**RE: Pontilux - 1301 Cuesta Abajo Ct NE**  
**Grading and Drainage Plan**  
**Stamp Date: 4/3/17**  
**Hydrology File: D13D002H**

Based upon the information provided in your submittal received 4/7/2017, the Grading and Drainage Plan **is not** approved for Grading Permit. The following comments need to be addressed for approval of the above referenced project:

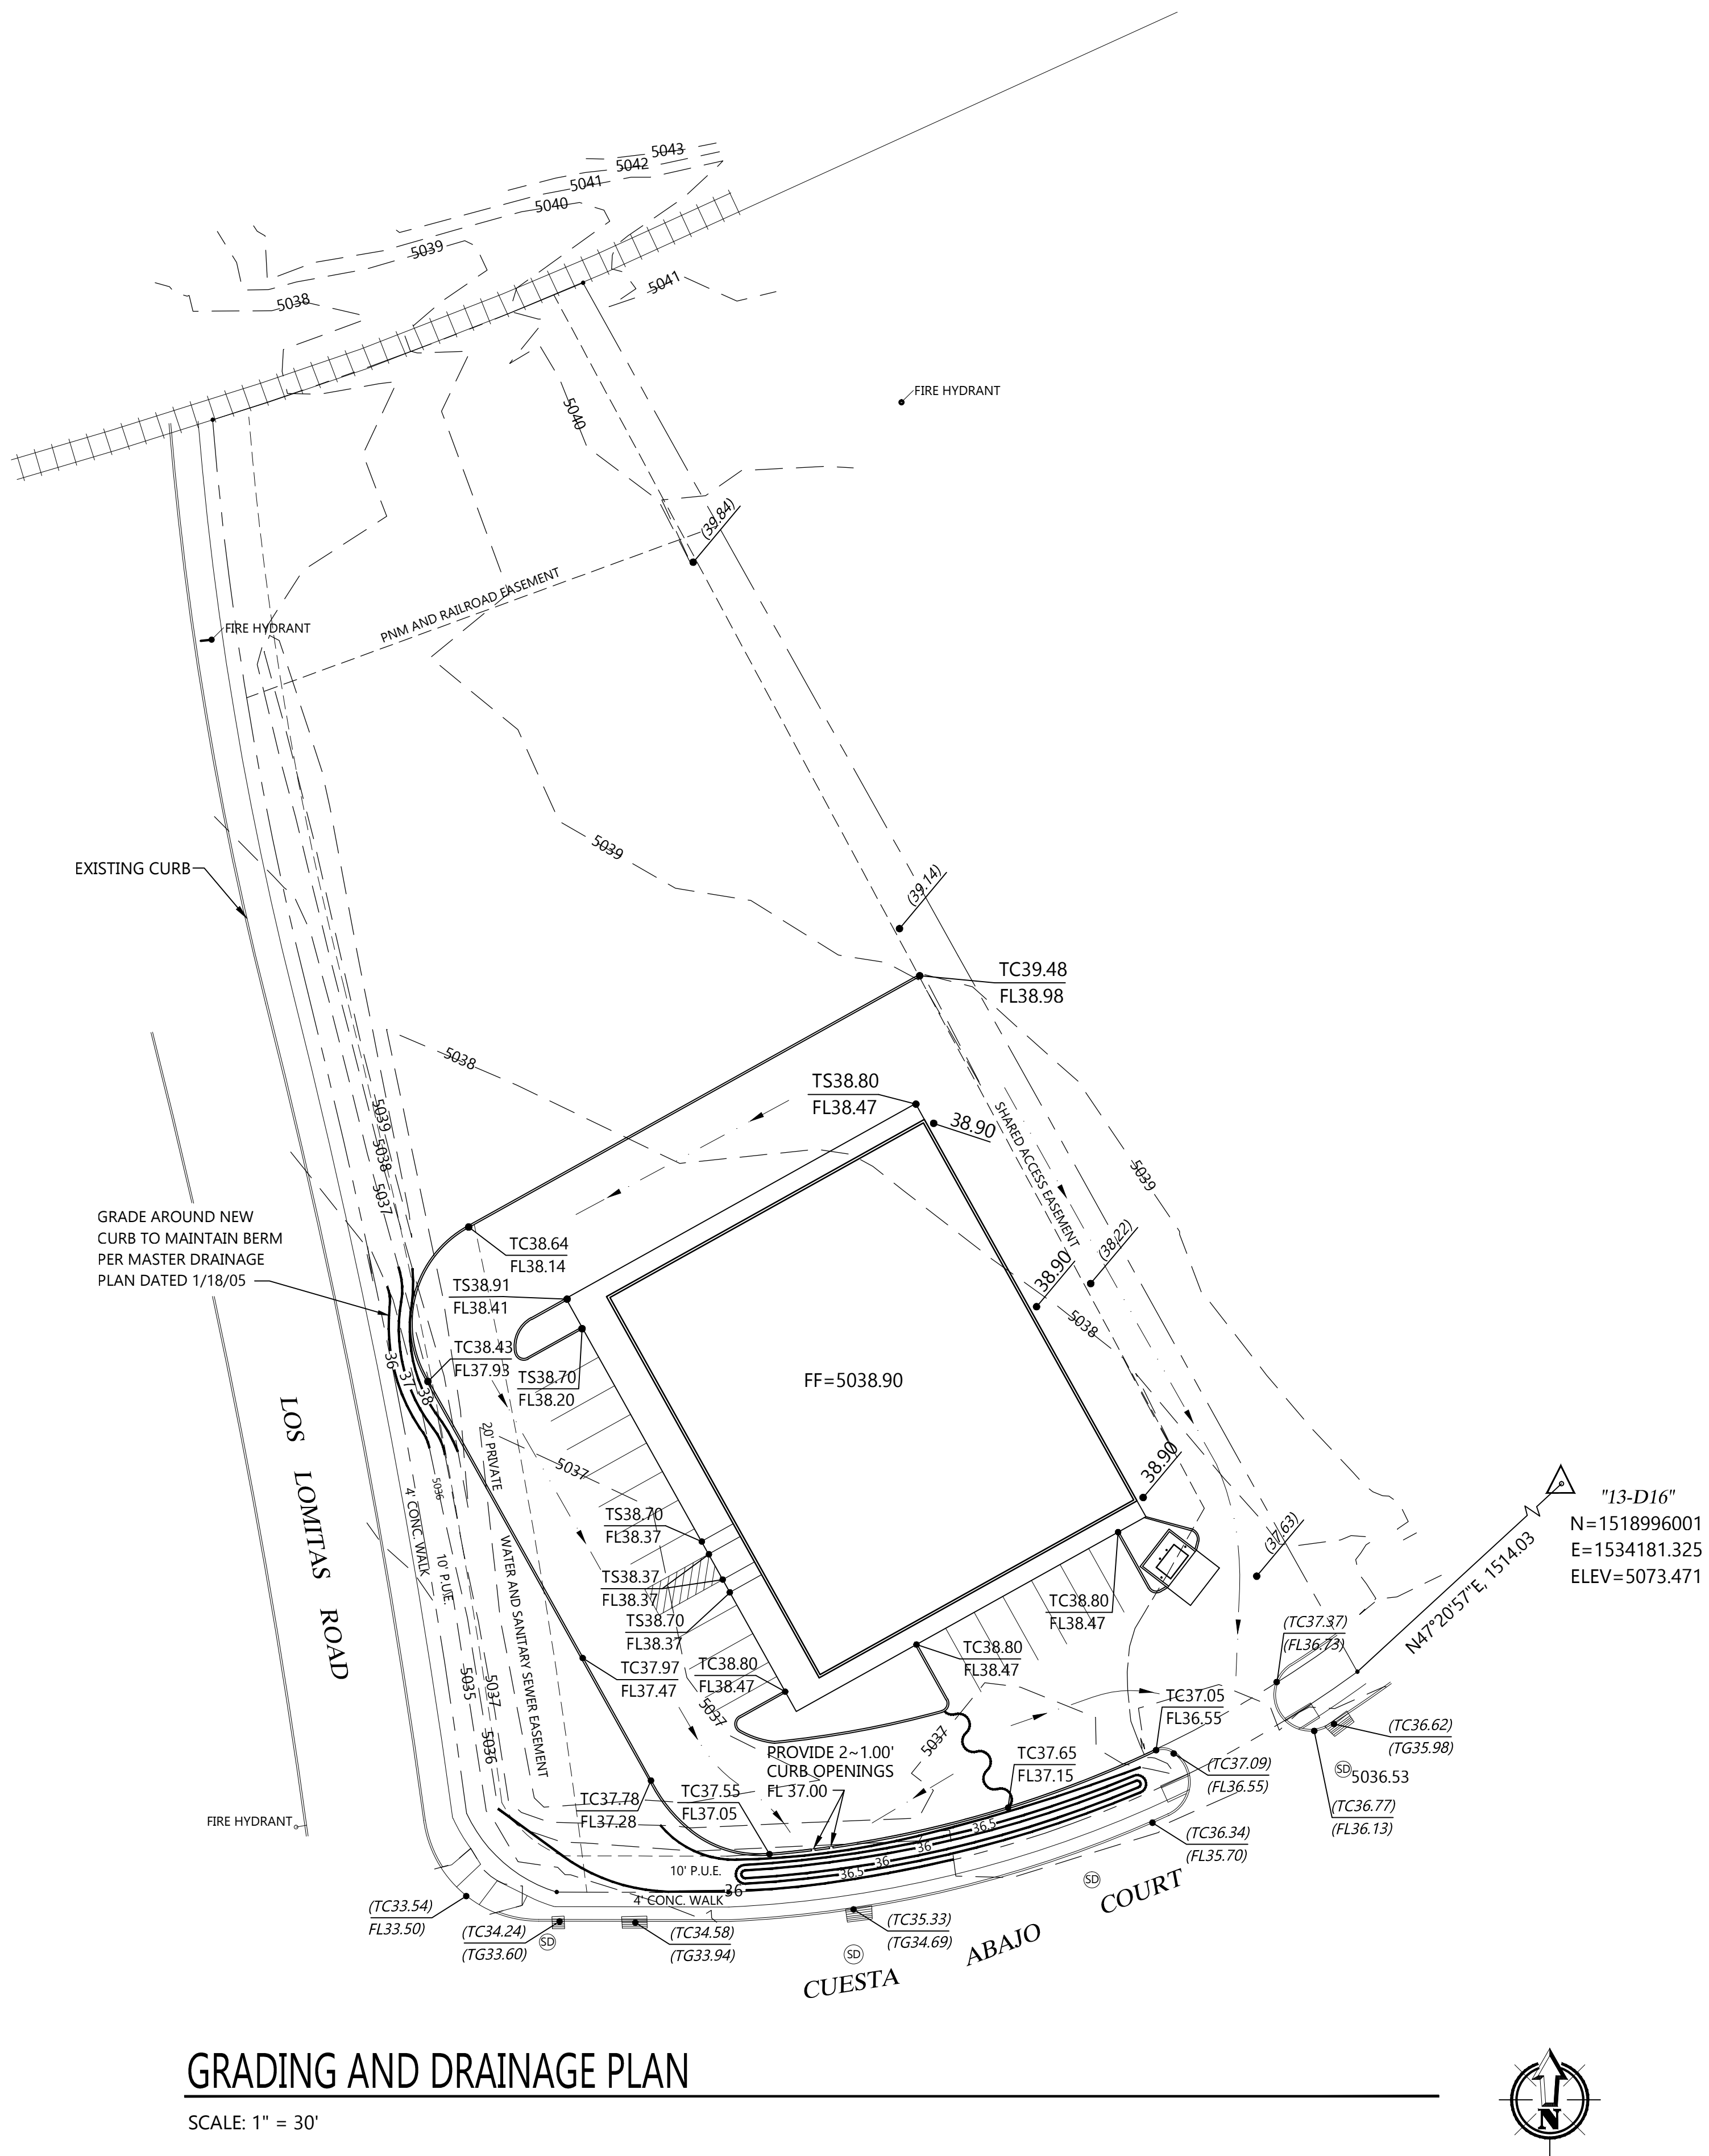
1. This site is part of a Master Drainage Plan by Mark Goodwin and Associates engineer's stamp date of 1/18/05. Please address this in the drainage narrative for the existing conditions.

2. As part of this Master Drainage Plan, there is a maximum allowable Q that is allowed for this tract. Please note that the proposed Q is below this. Please add this maximum allowable Q in the drainage narrative.

3. Under your drainage calculations, the existing conditions needs show the existing asphalt in the shared access easement. Also, the proposed conditions needs to address this existing asphalt as well.

4. Please add the following information to the Grading Plan:
  - a. Shared access agreement along the east property line.
  - b. Existing pavement and grades on this pavement.

- c. Existing 100 ft easement along the north property line.
  - d. Existing inlets on Cuesta Abajo Ct. There are four of them adjacent to the property. Please include the TC and FL elevations.

- e. Existing TC and FL of the existing driveway curbing.
  - f. Please label/hatch the existing curb along Los Lomas Rd. It disappears in all of the line work.

- g. Please label/hatch the proposed curb along Cuesta Abajo. It disappears in all of the line work.
  - h. Please show the existing ramps at the corner of Los Lomas & Cuesta Abajo and the existing driveway.

- i. Please label/hatch the existing berm along Los Lomas.
  - j. Please label or put in the legend the water block/high point.
5. Please add a water block/high point symbol at the NW corner of the proposed pavement.

6. The proposed pavement is cutting into the existing berm. This berm was placed per the Master Drainage Plan along Los Lomas to divert the site drainage towards the inlets on Cuesta Abajo. Please show how you are going to continue this drainage pattern. Such as re-contouring the berm behind the proposed curb so no drainage will spill onto Los Lomas.
